STATE OF NORTH CAROLINA  
DEPARTMENT OF TRANSPORTATION

**Addendum No. 1**

**Cabarrus County (B-5808)**

BRIDGES #57 AND #59 OVER IRISH BUFFALO CREEK ON US-29 AND US-601.

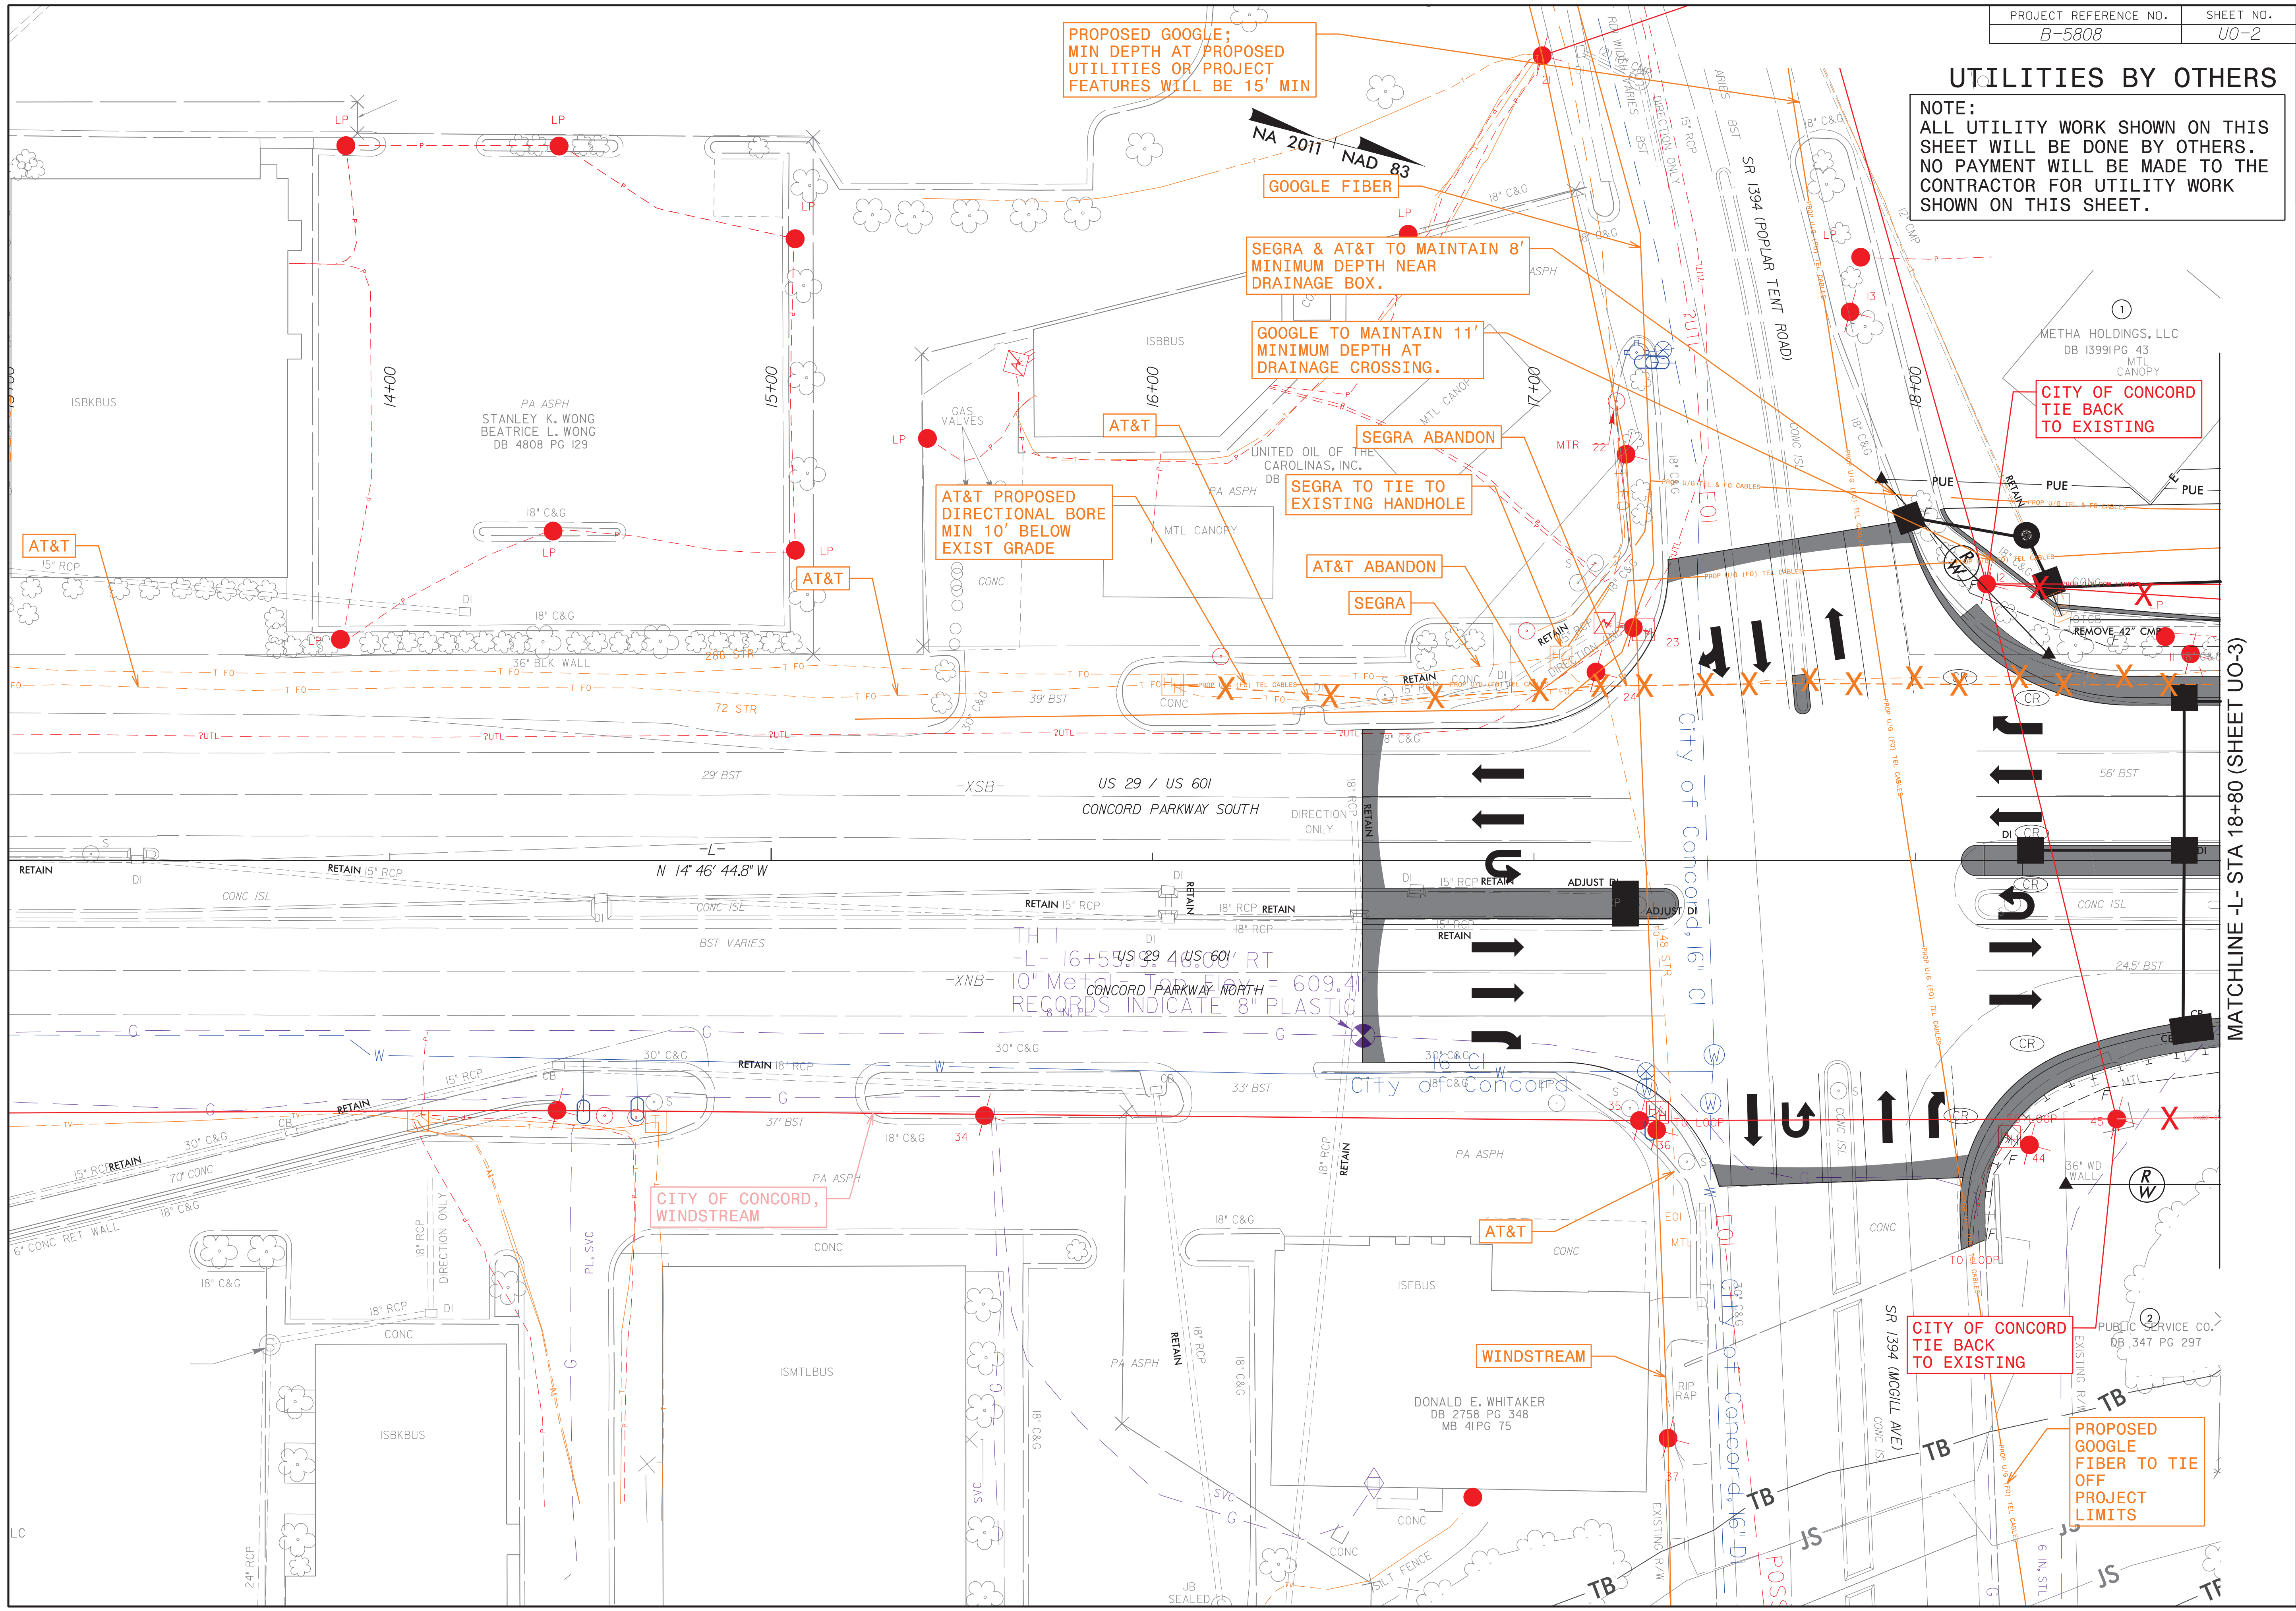
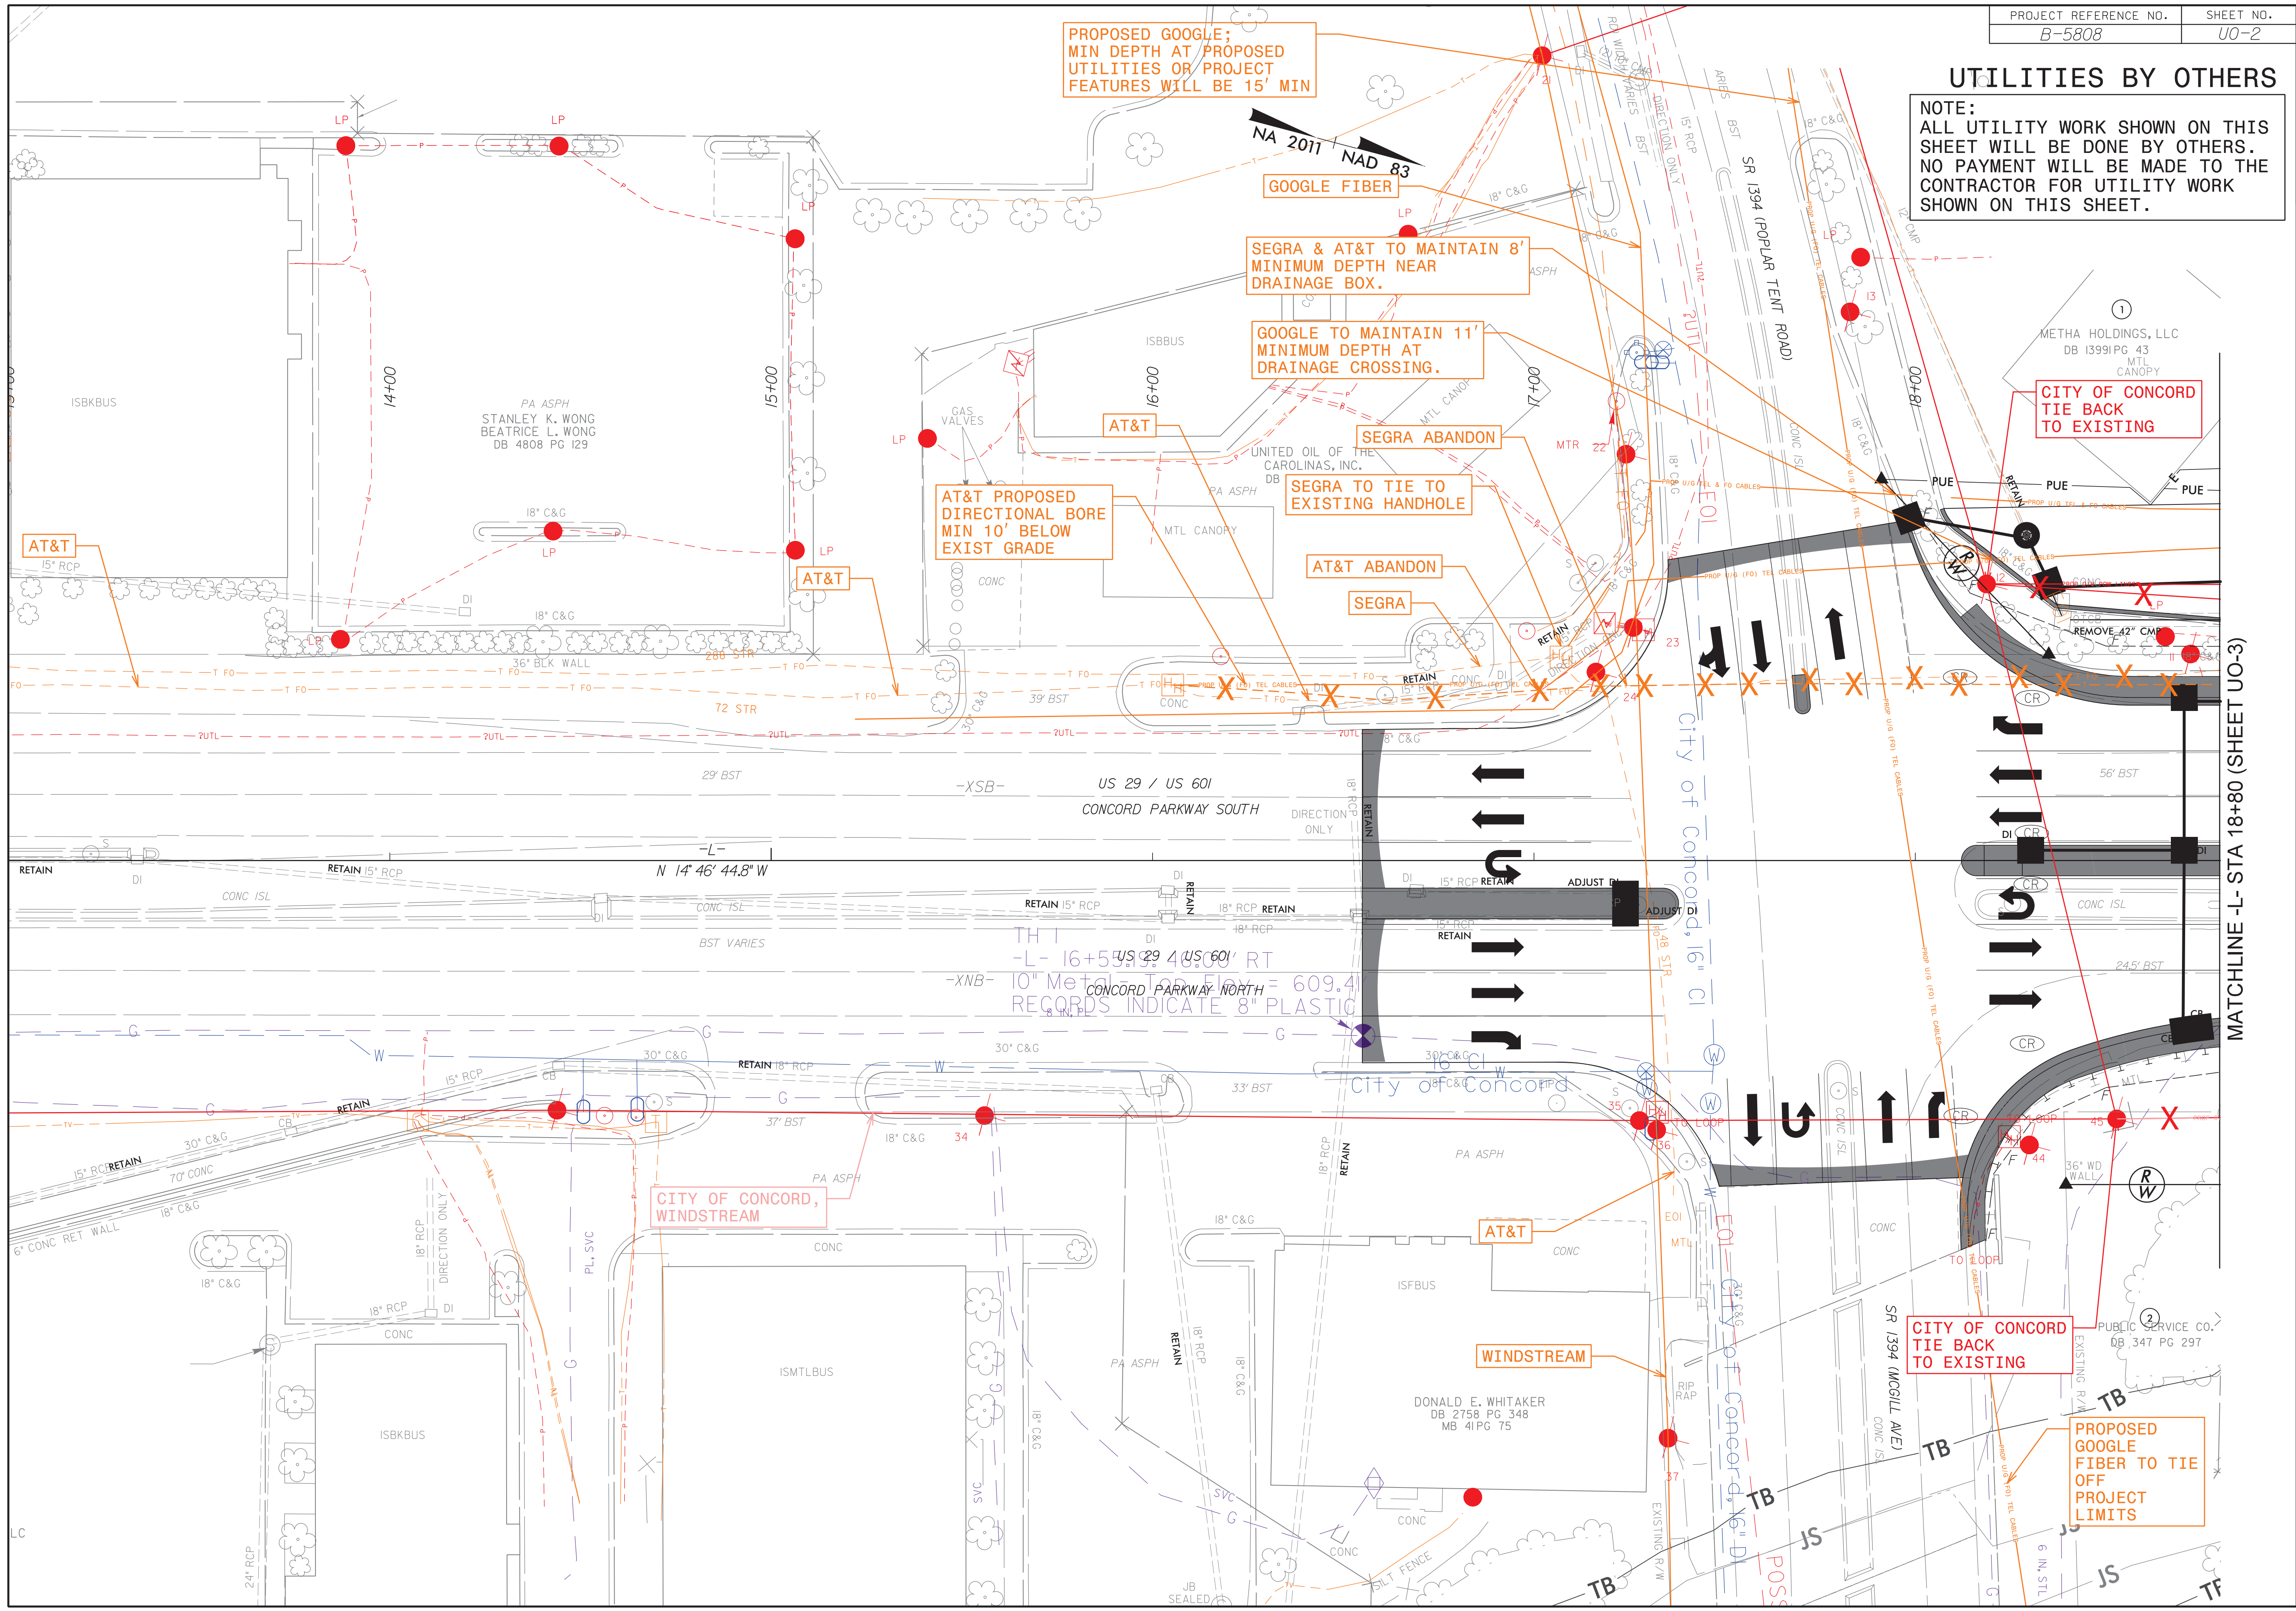
Sheet No.	Revision
UO-1 thru UO-4	Sheets revised to include Google Fiber.

- 1) Google will install their underground facilities on the north side of Poplar Tent Road, cross under US 29/US 601 at a minimum depth of 15 feet, and tie back to their existing facilities on McGill Avenue outside the project limits. Google also plans to install an underground fiber on the west side of US 29/US 601. They plan to be 3 feet deep at the 42-in drainage crossing, so the contractor will coordinate with them during that drainage installation. This is all new construction, so no completion date has been finalized.
